Hill Top Farm,
Eastfield Lane,
Thurgoland,
S35 7AY.

Ref: Conversion of agricultural buildings to provide accommodation:
Unit 1 and Units 2 - 5.

This supplementary report follows receipt and review of drawings from Ibbotson Architects which illustrate the layout of the proposed units. Also, preliminary calculation in which I assess the loads which will be imposed on the structure by the proposed alterations. I deal with the main elements of the structure as follows:-

TITLE:
**Proposed Elevations
UNIT 1**

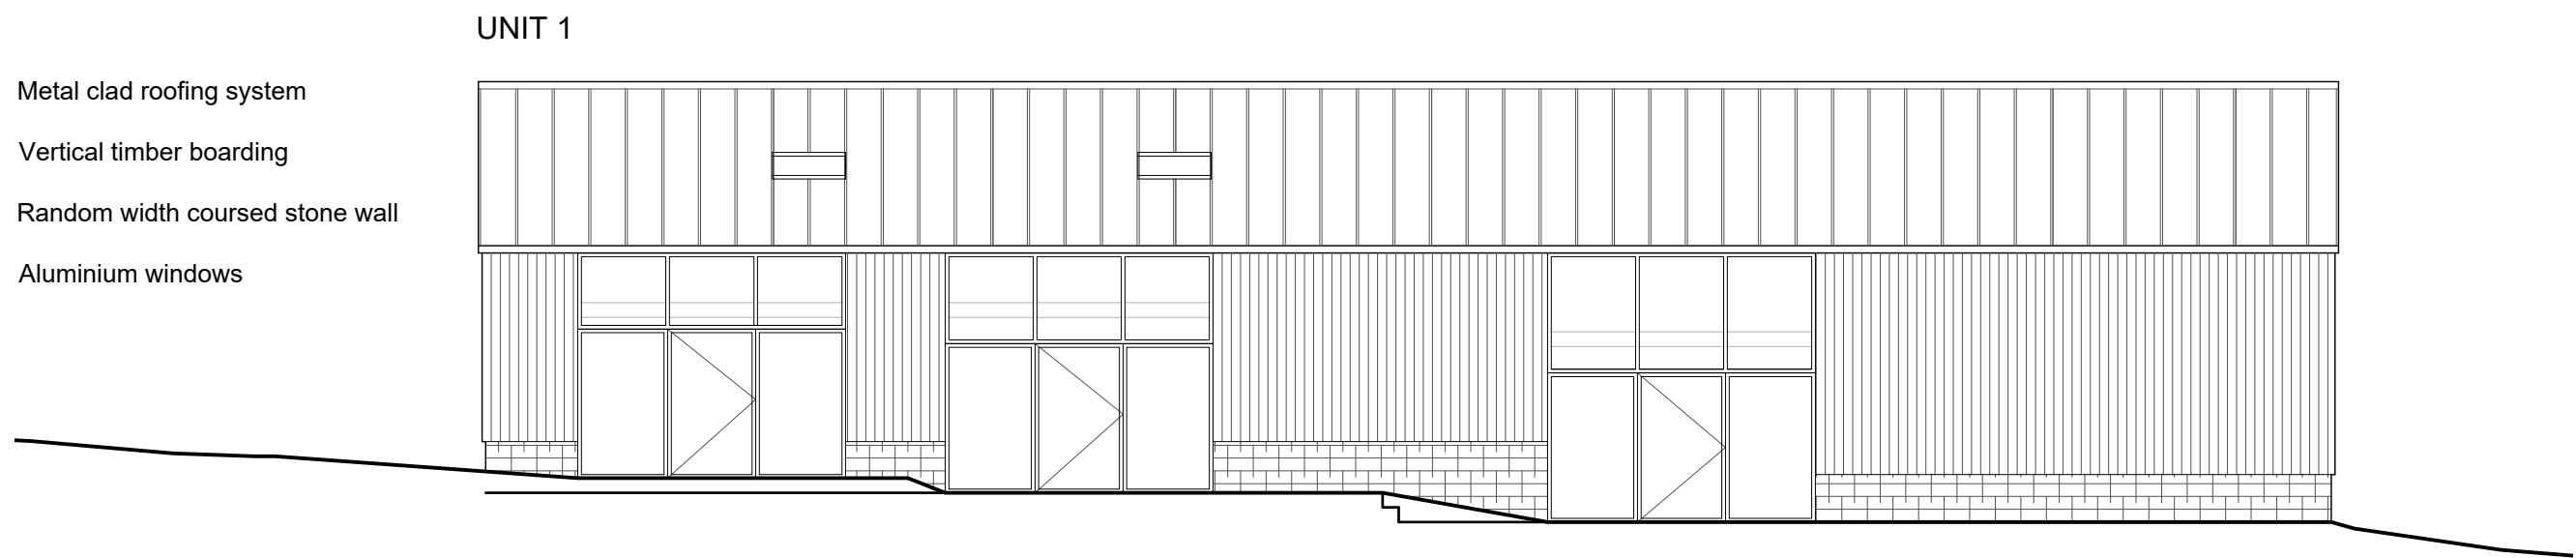
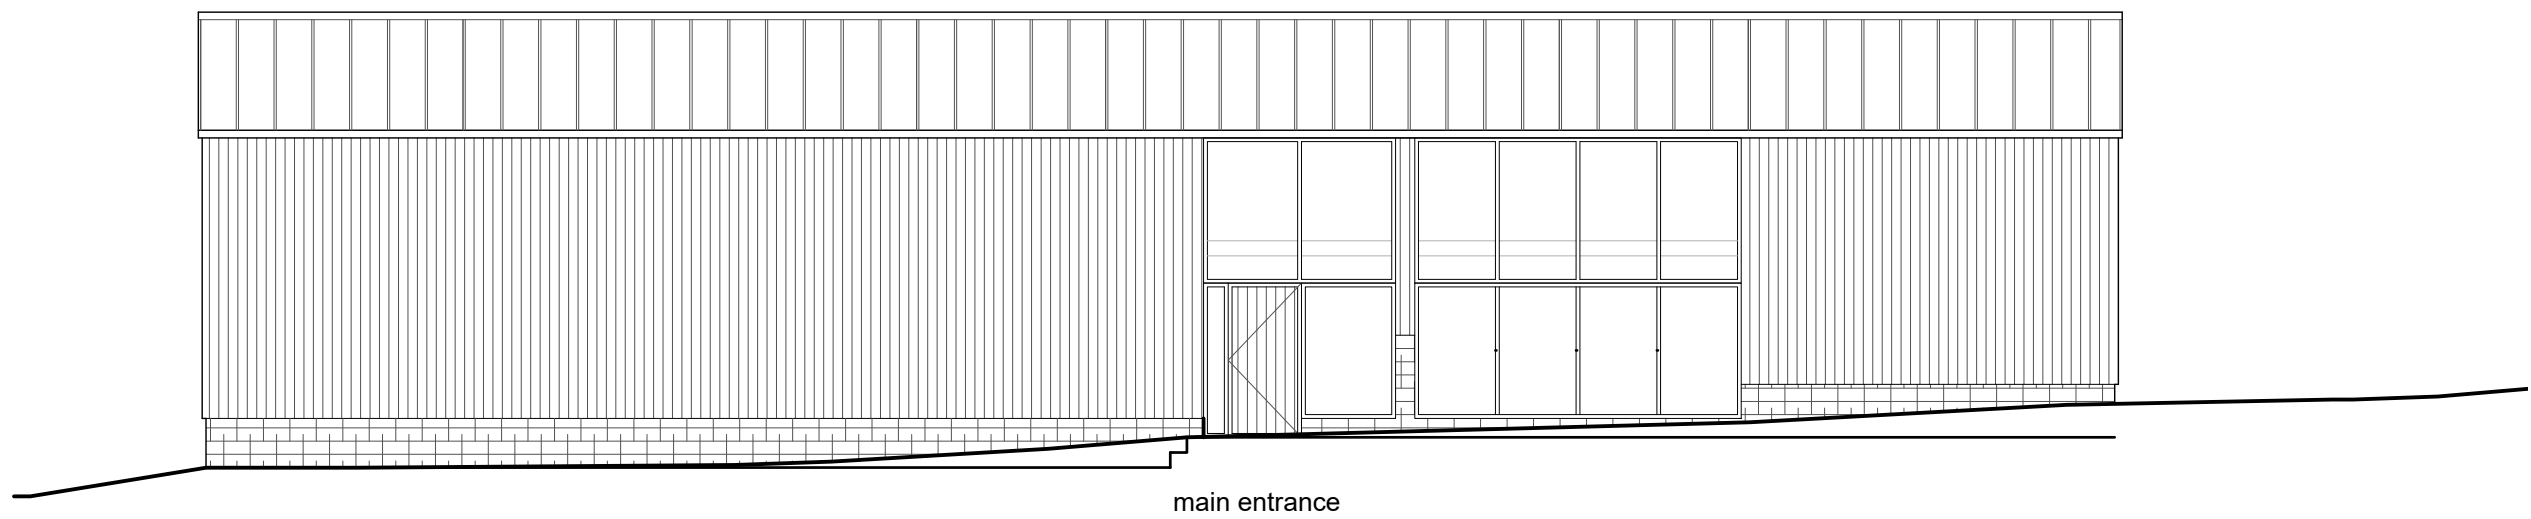
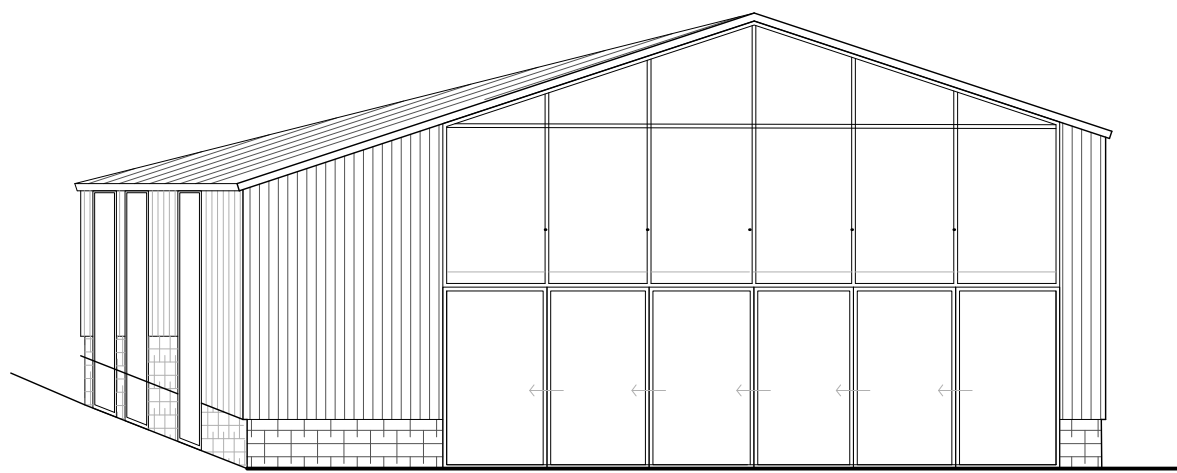
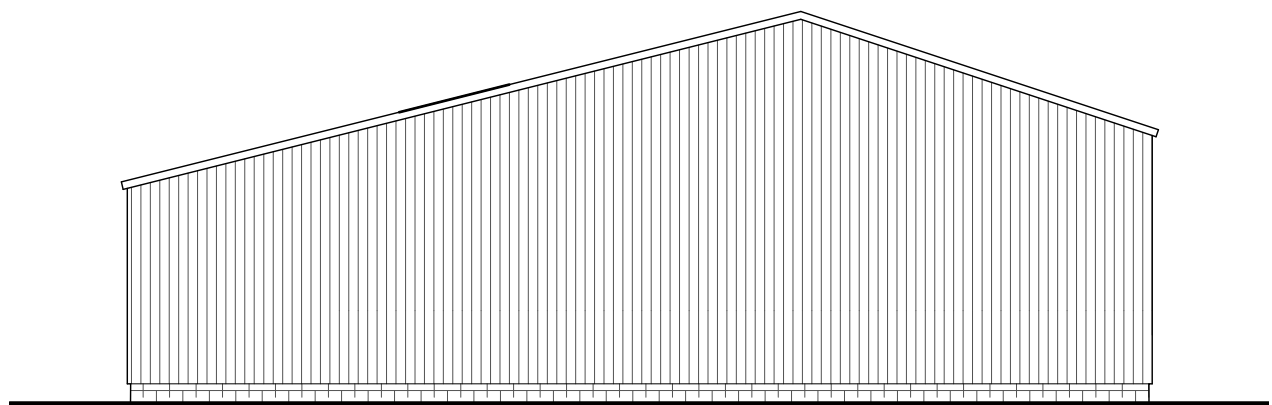
Elevations: Although some elevations are to be provided with a number of apertures, I am confident that the stability of the structures will not be jeopardised. The introduction of steel posts to frame these apertures will ensure the maintenance of stability. Similarly, measures will be taken to ensure that the removal of the end wall of Unit 1 will not compromise the structural integrity of the remainder of this building. Furthermore, the installation of the new end wall is secondary to the primary structure of the building.
